# Rezoning Transportation Analysis

Petition Number: 2024-003

**From:** Jake Carpenter, PE

Date	Description
02-21-24	First Review (IW)
03-20-24	Second Review (IW)
04-24-24	Third Review (DR)
05-07-24	Trip Generation Update
05-59-57	Fourth Review (KC)

SHEET NUMBER  
**RZ-2**

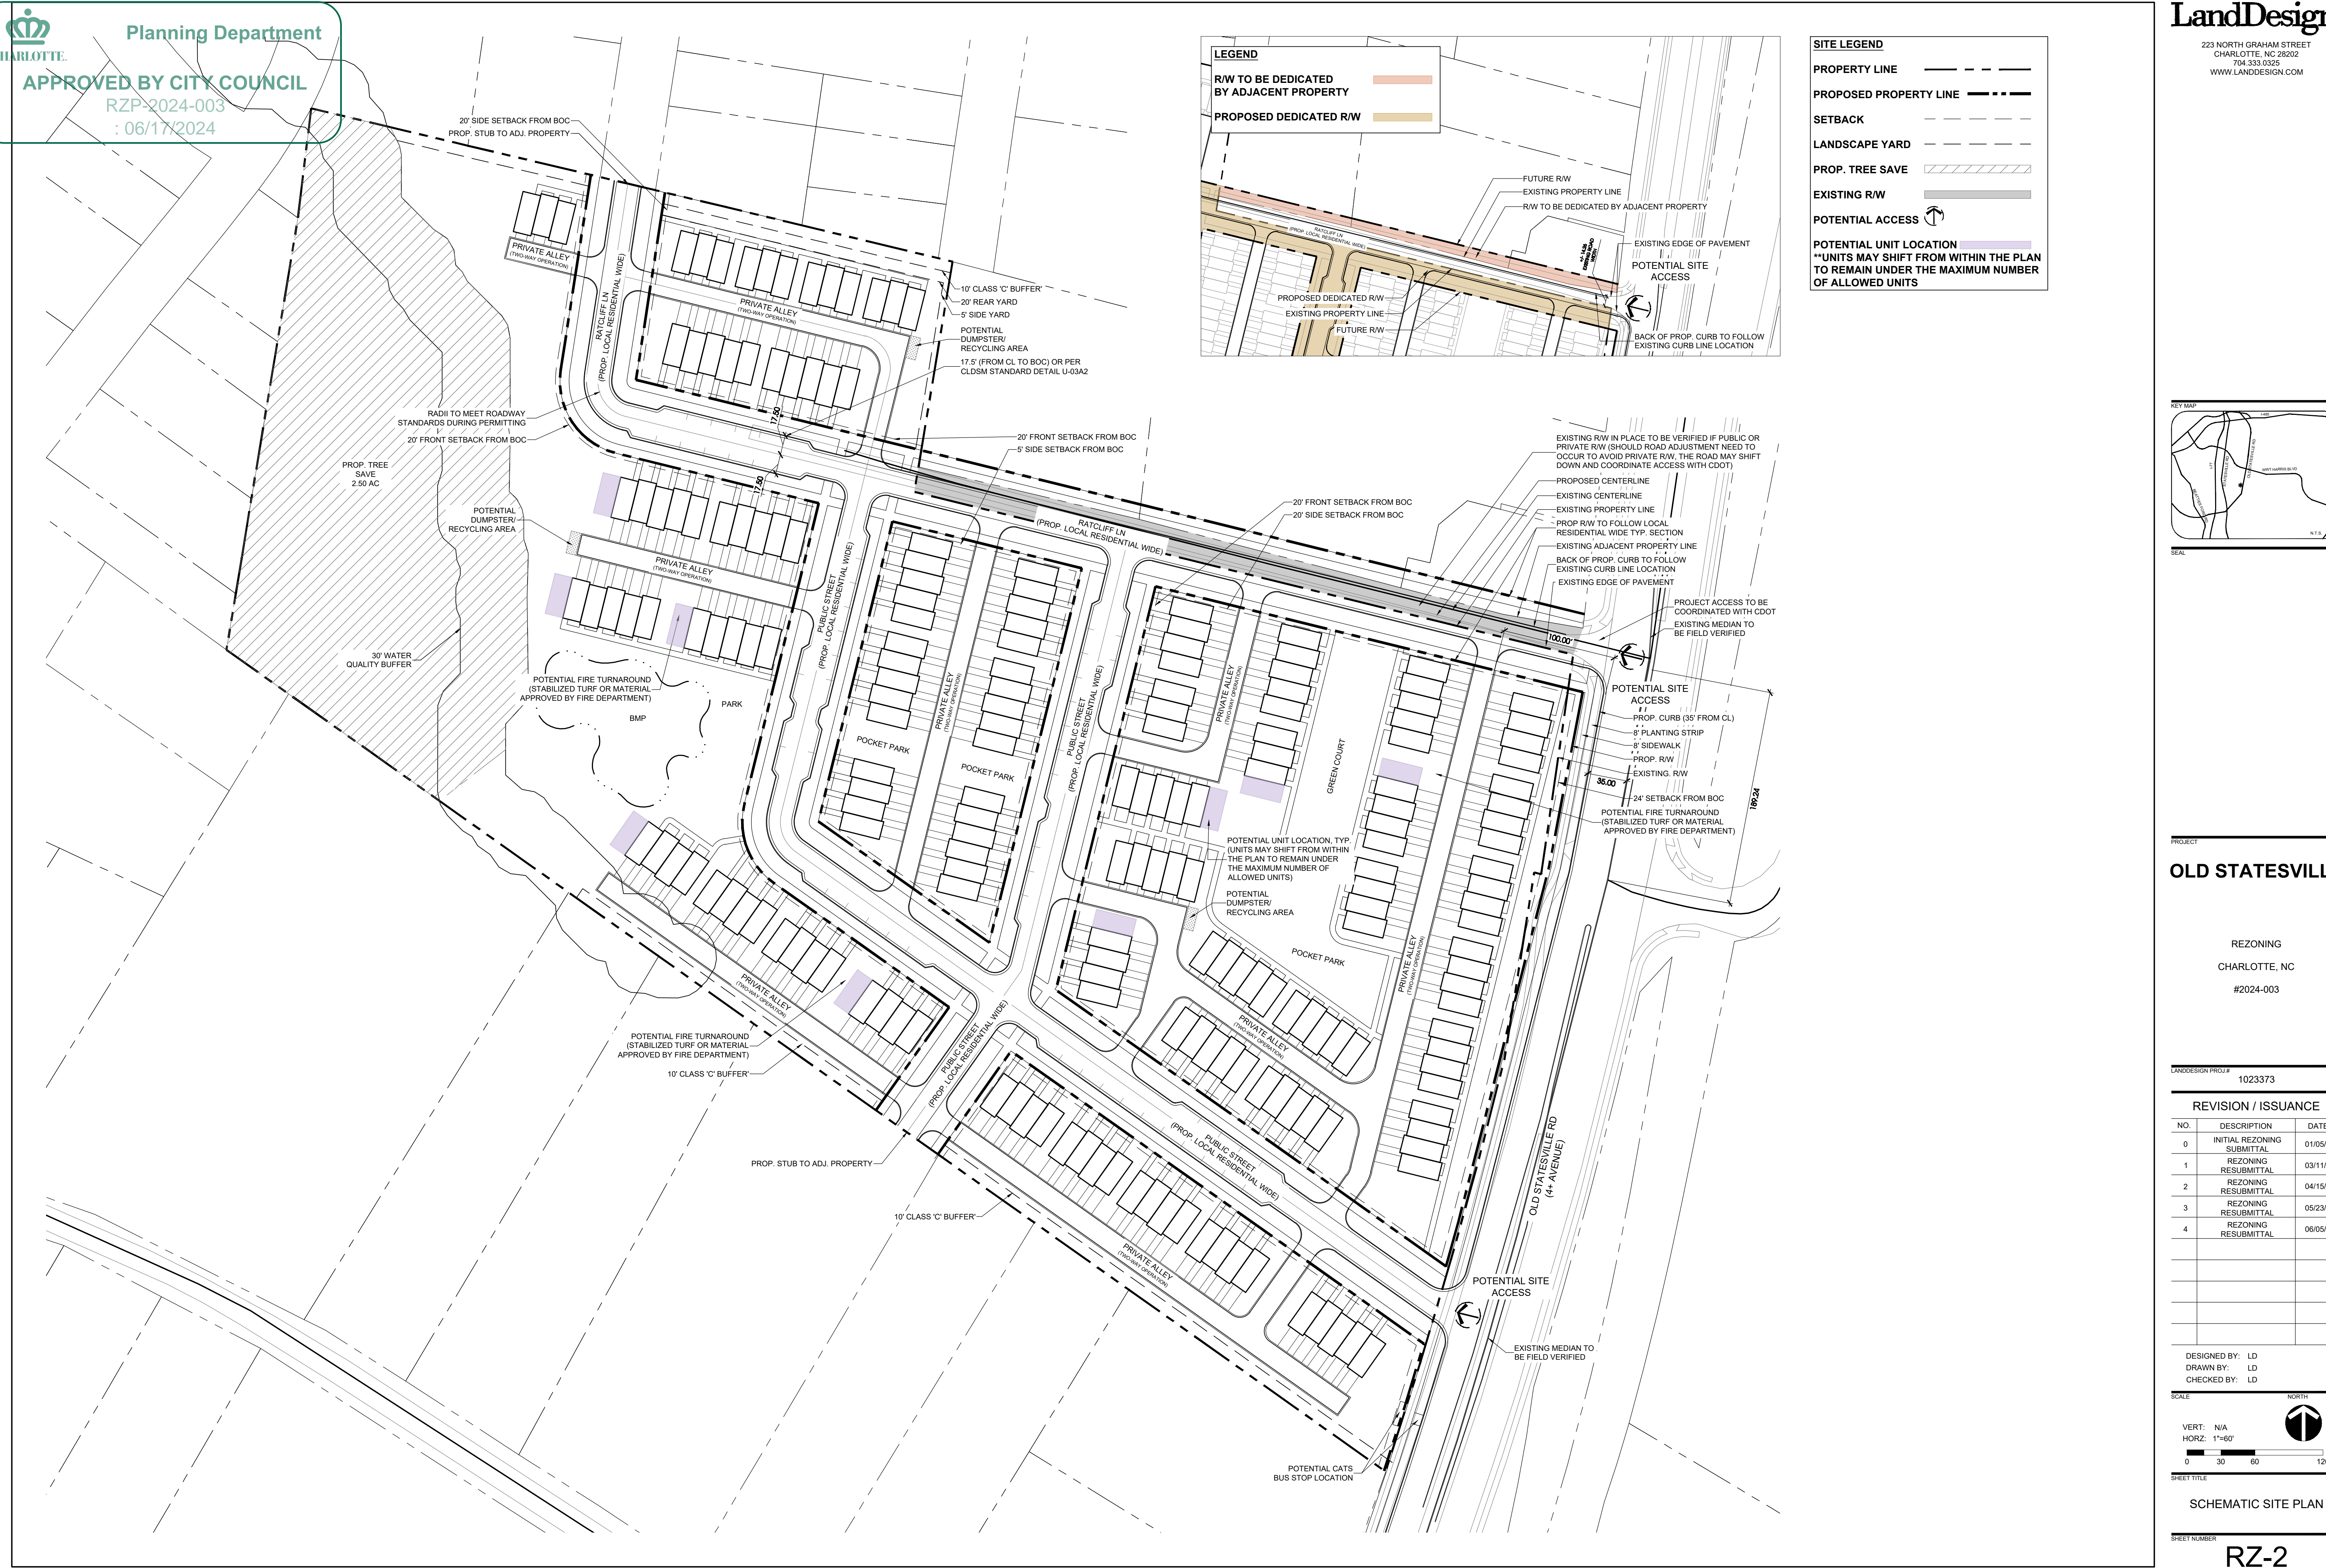
**Clarifying Comment 05-29-24:** Label and dimension curb and gutter from centerline for all roads shown on site plan.

**Clarifying Comment 03-20-24:** The site plan calls out curb line to match existing but does not state what that existing dimension is. Conditional note 3.g. states that future boc is 17.5'. Add additional information to call out on site plan to show that both of these items are stating 17.5' from centerline.
